Revision #5 narrative (Kitchen redesign)

DATE: May 31, 2023  
PROJECT ARCHITECT: ELEVEN18 ARCHITECTURE, PL  
CONTACT NAME AND NUMBER: Matt Conte, 407-745-5300

**PROJECT NAME:** The Springs of Ballentine  
**PERMIT NUMBER:** N/A  
**PROJECT NUMBER:**  
**FID NUMBER:**

PLEASE NOTE THE FOLLOWING REVISIONS TO THE PROPOSED SET OF DRAWINGS HAVE BEEN COMPLETED  
IN RESPONSE TO REVISED FOOD SERVICE DRAWINGS.

## LIFE SAFETY PLAN

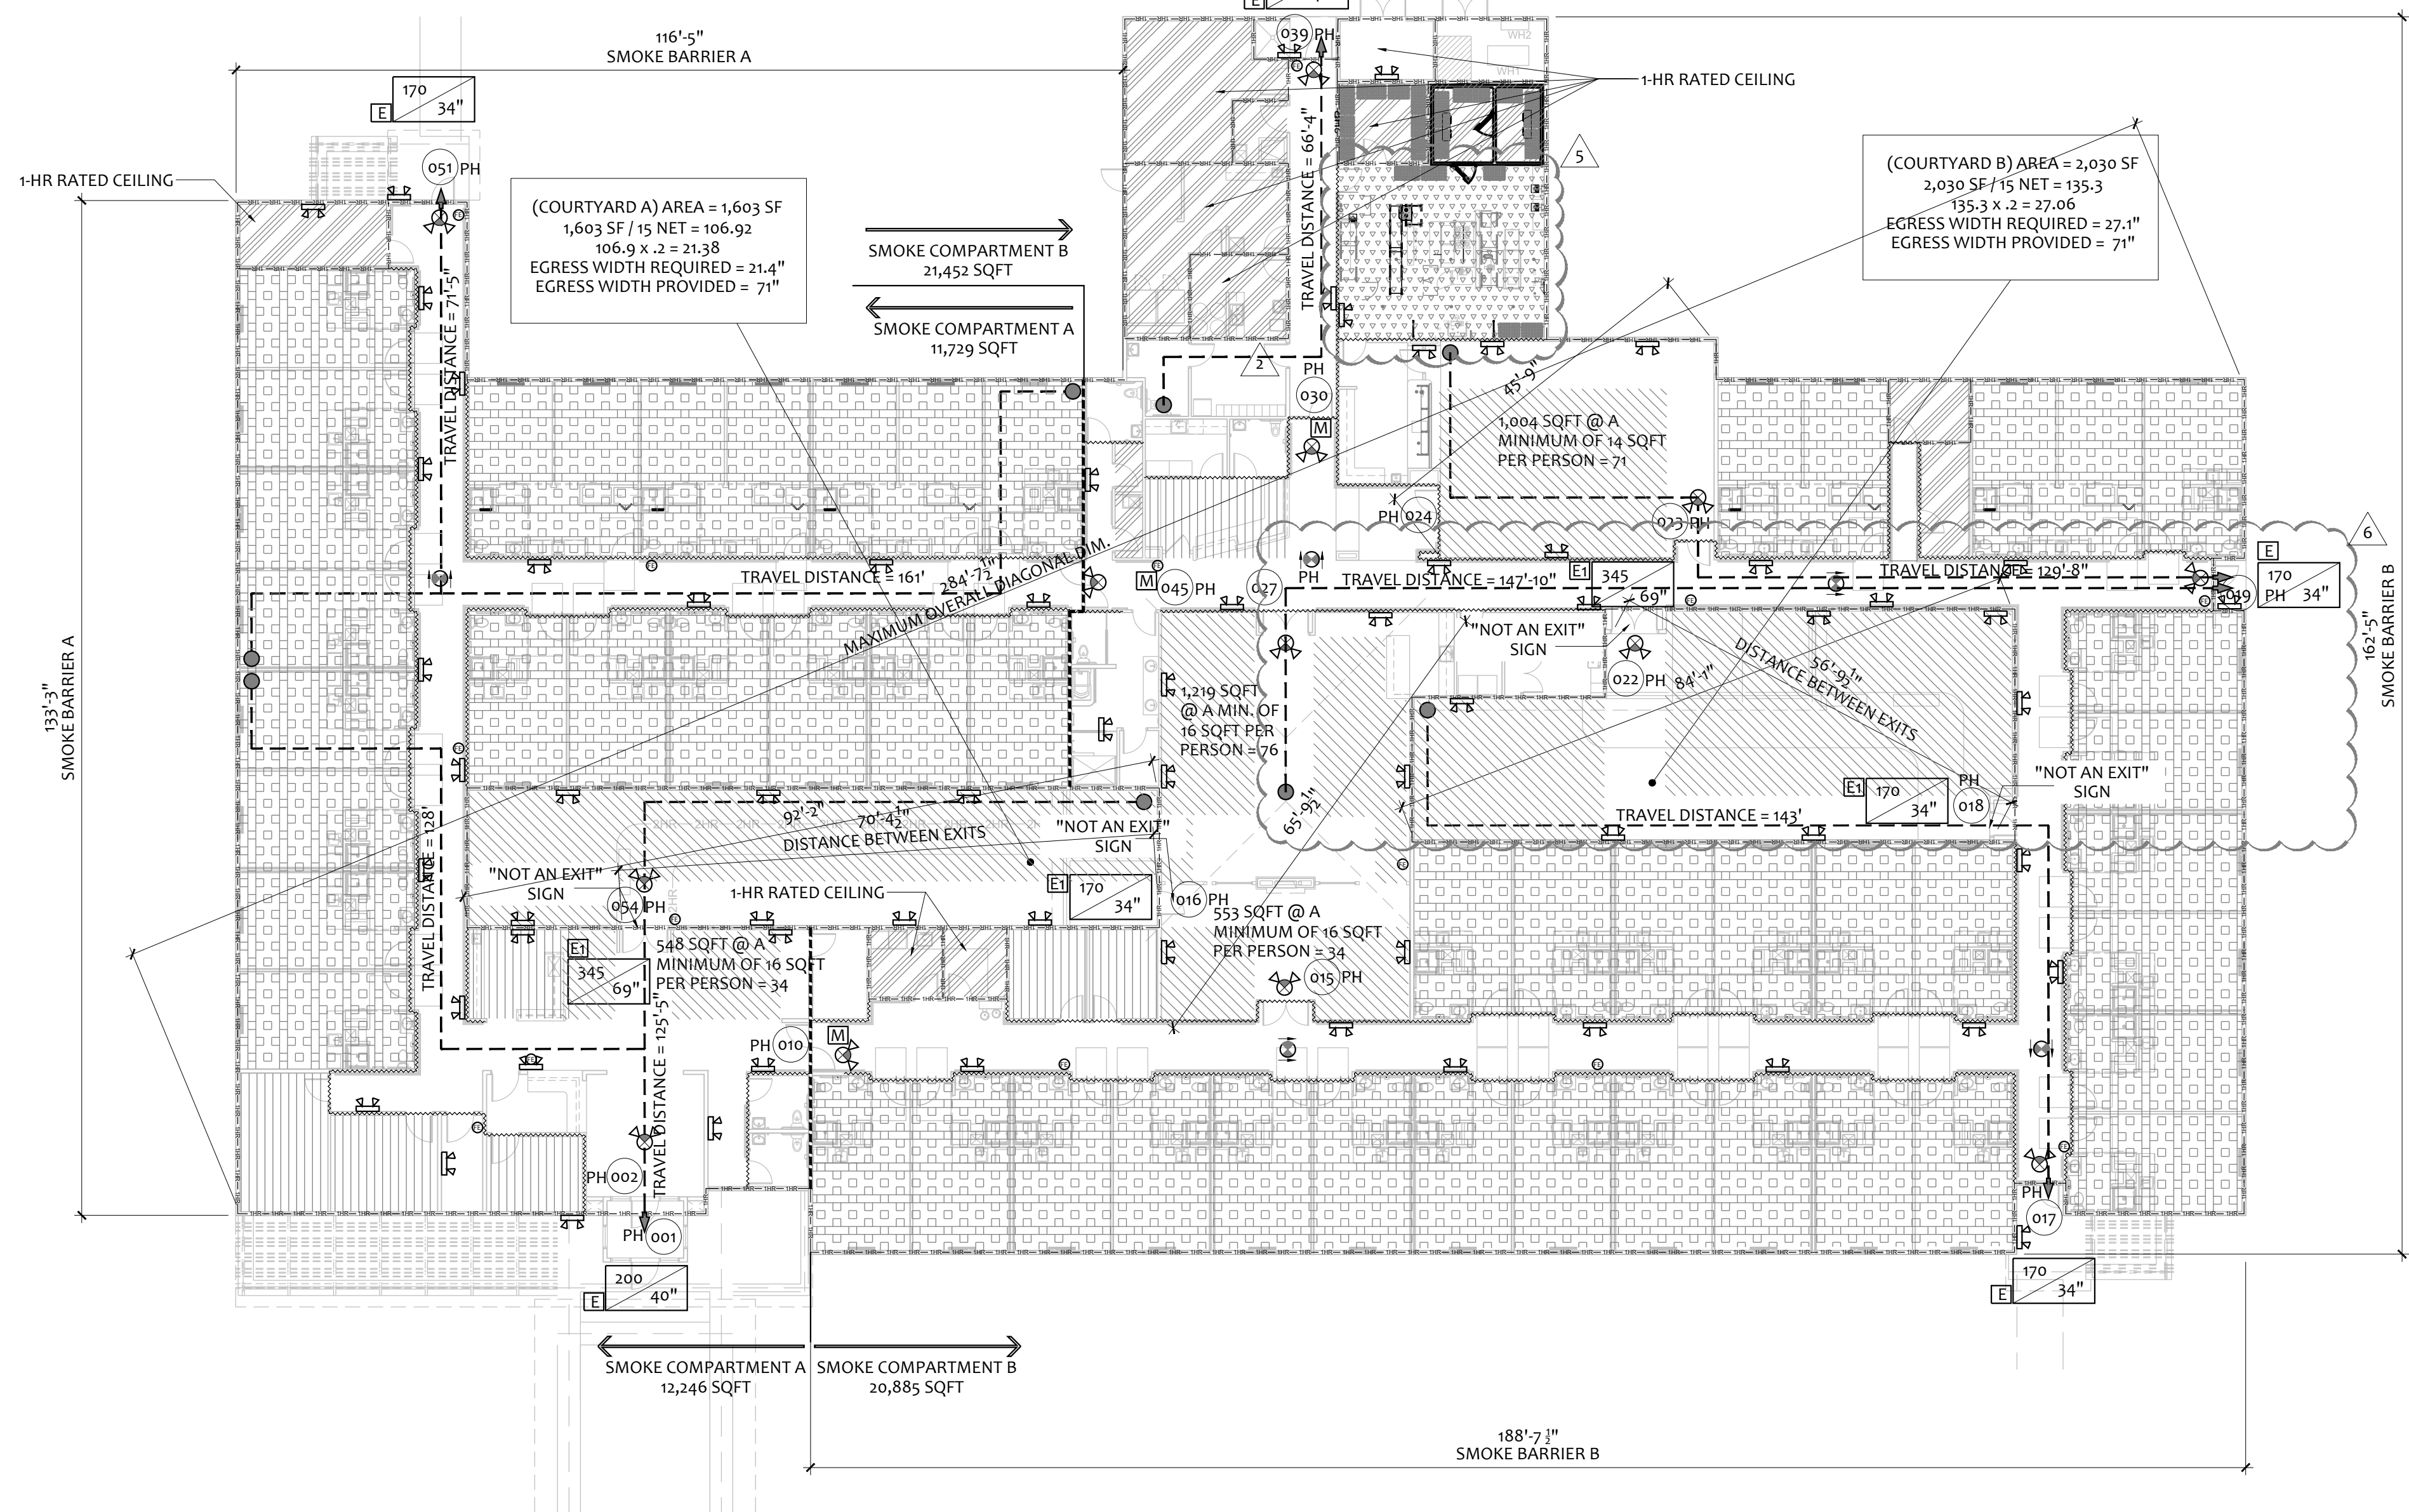
**A002**

Revised Kitchen equipment layout in life safety plan

**A201**  
 OVERALL FLOOR PLAN

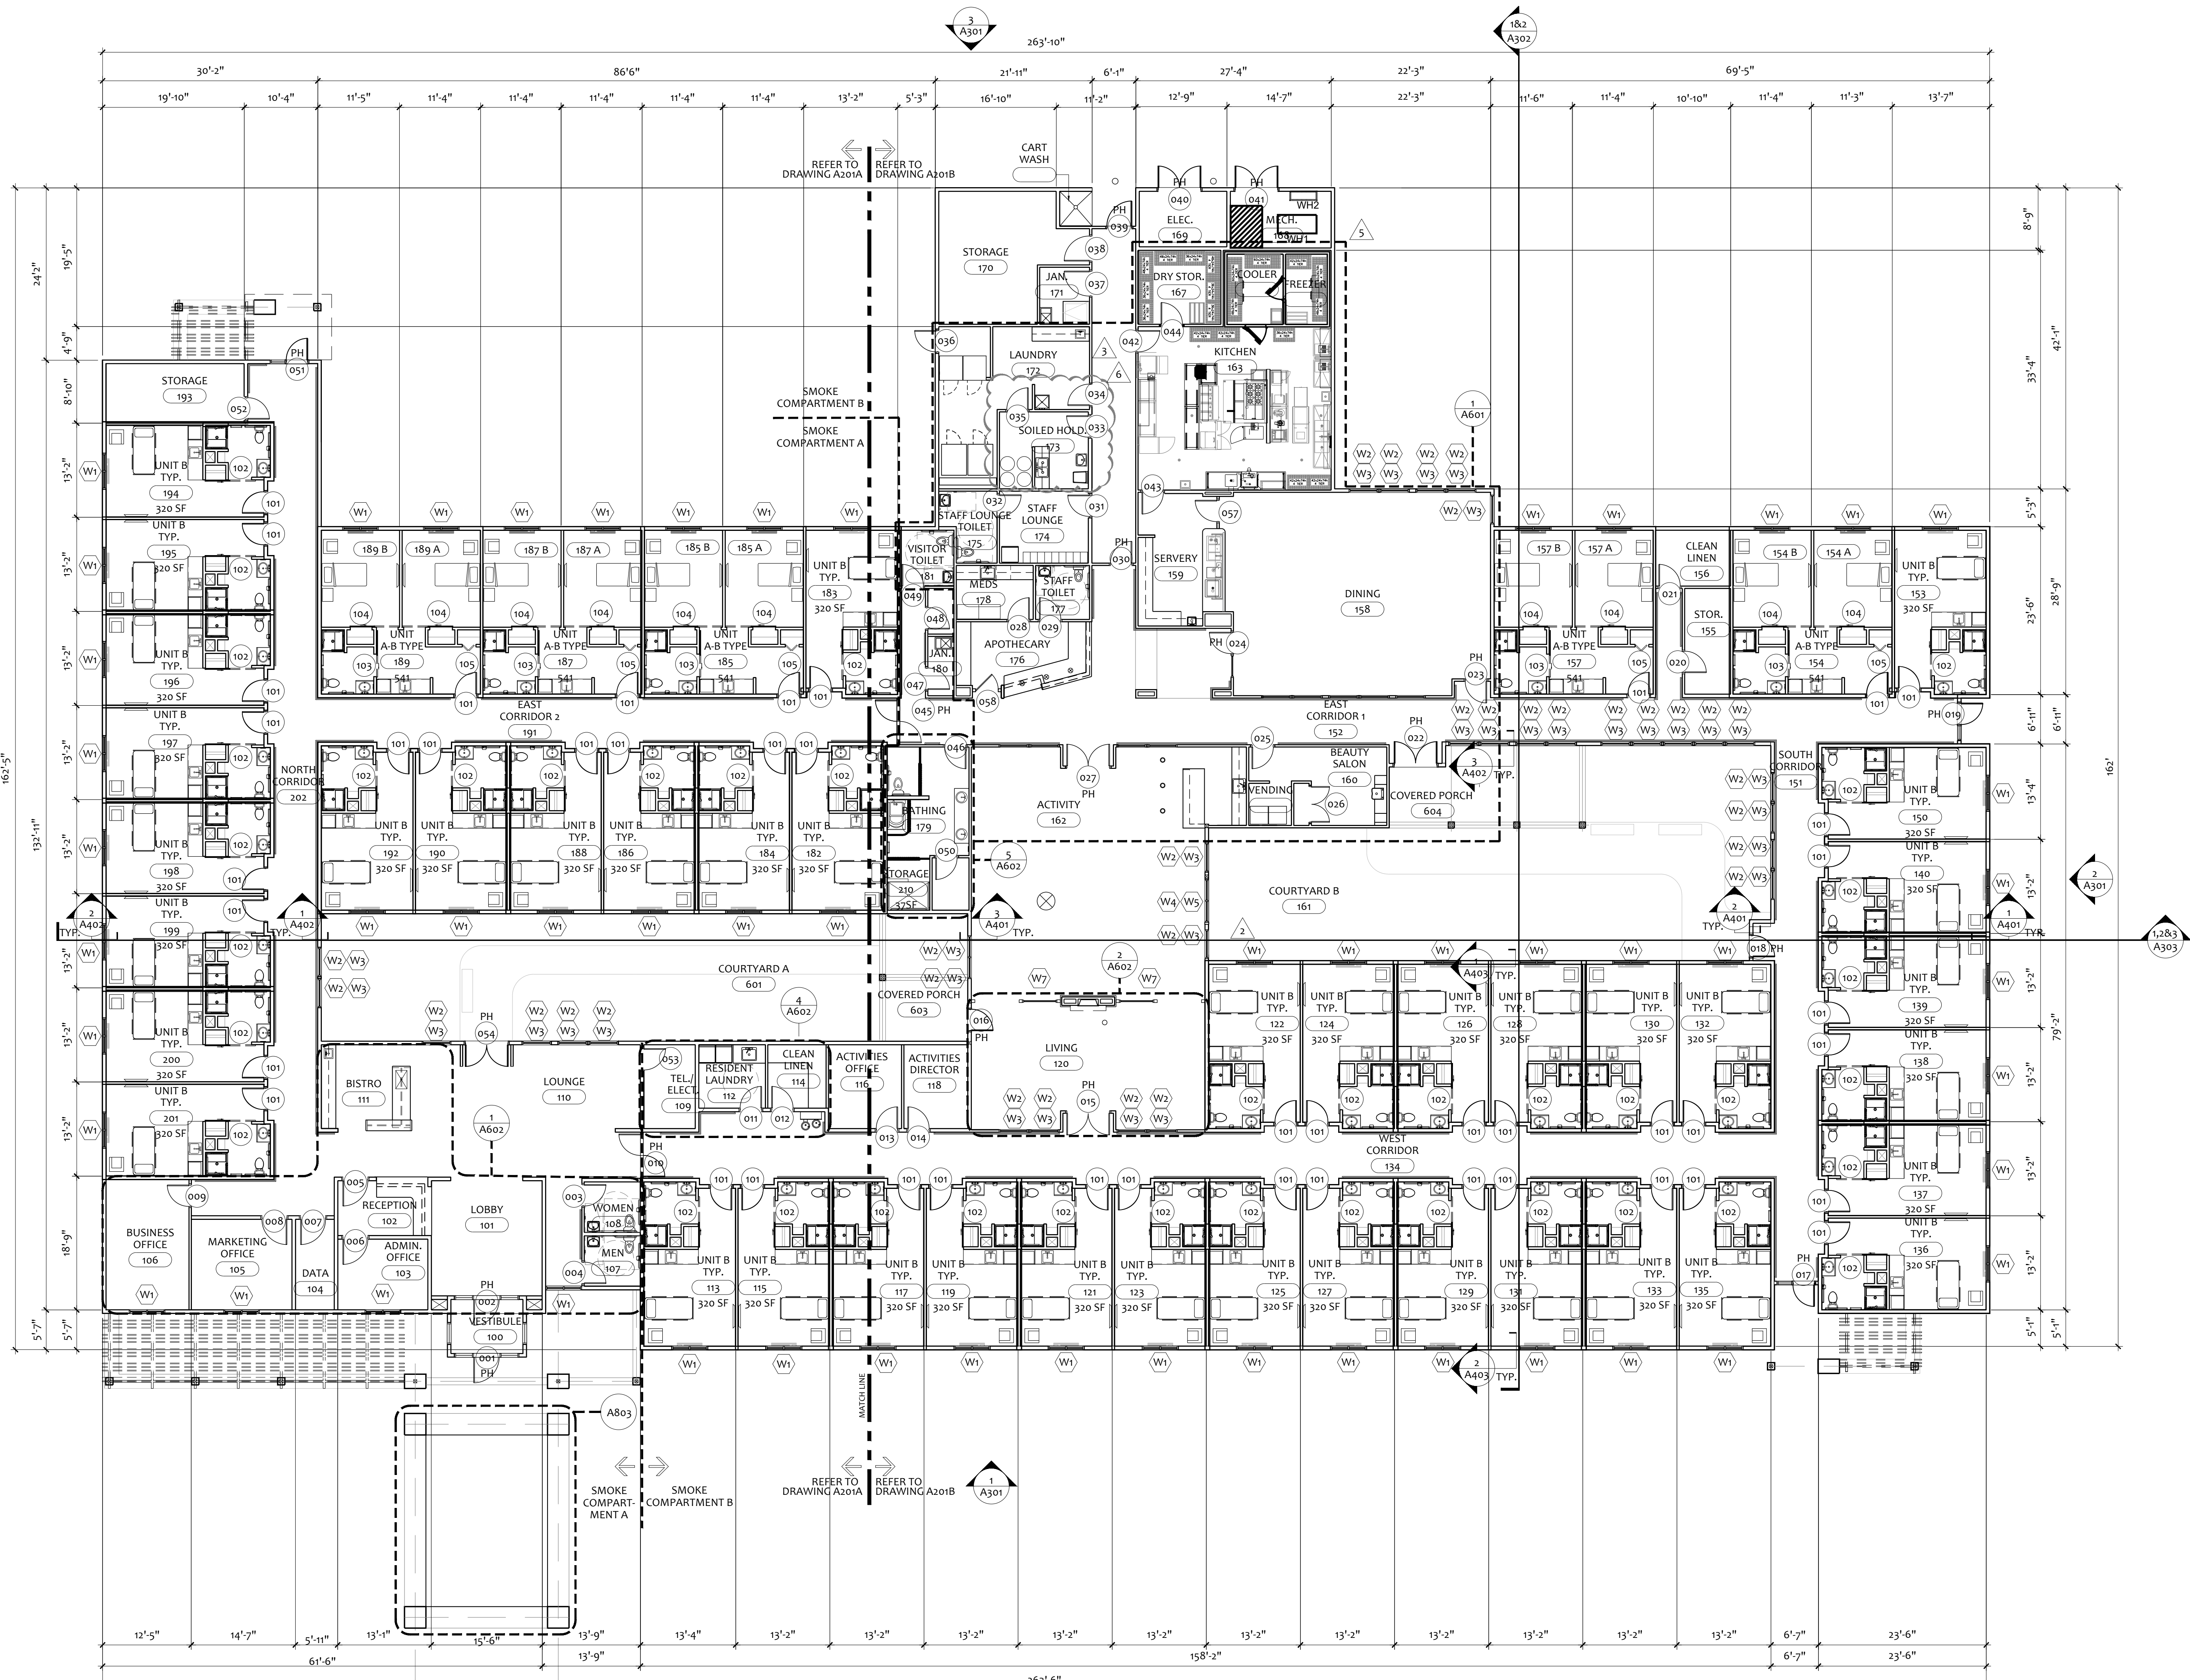
A201

Revised kitchen layout in overall floor plan

**A203**  
PARTIAL FLOOR PLAN

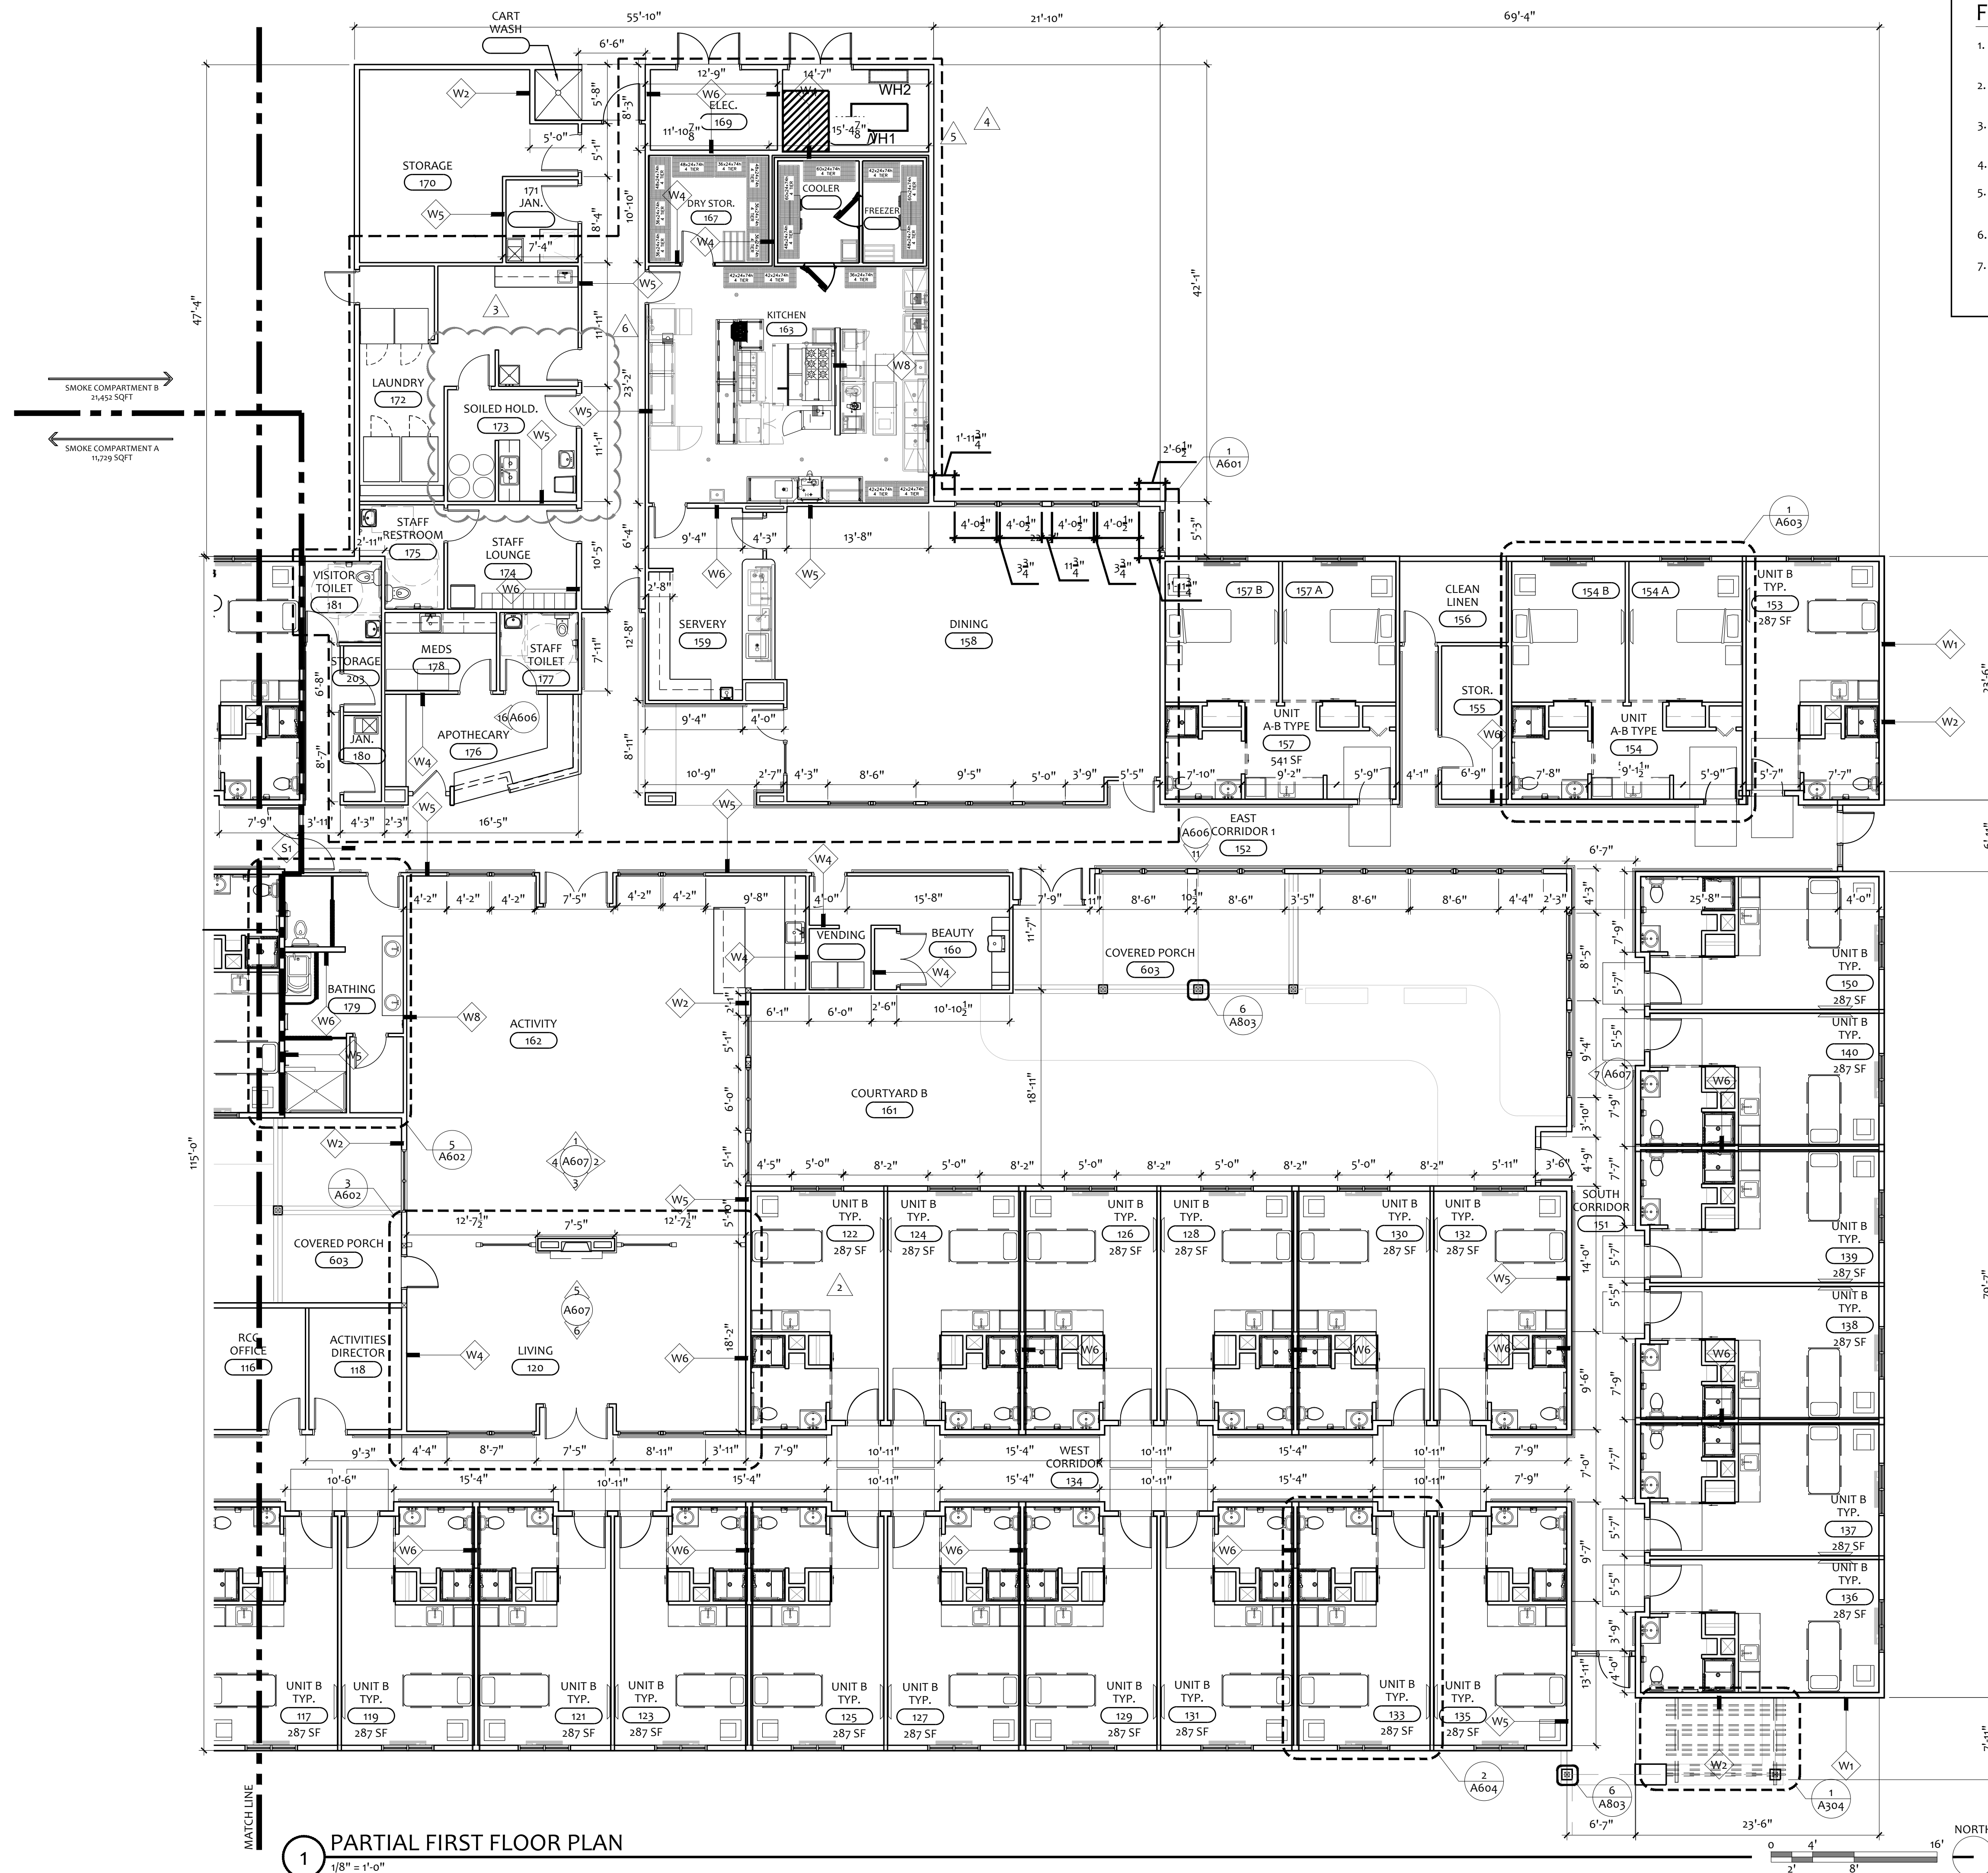
A203

Revised kitchen layout in partial floor plan
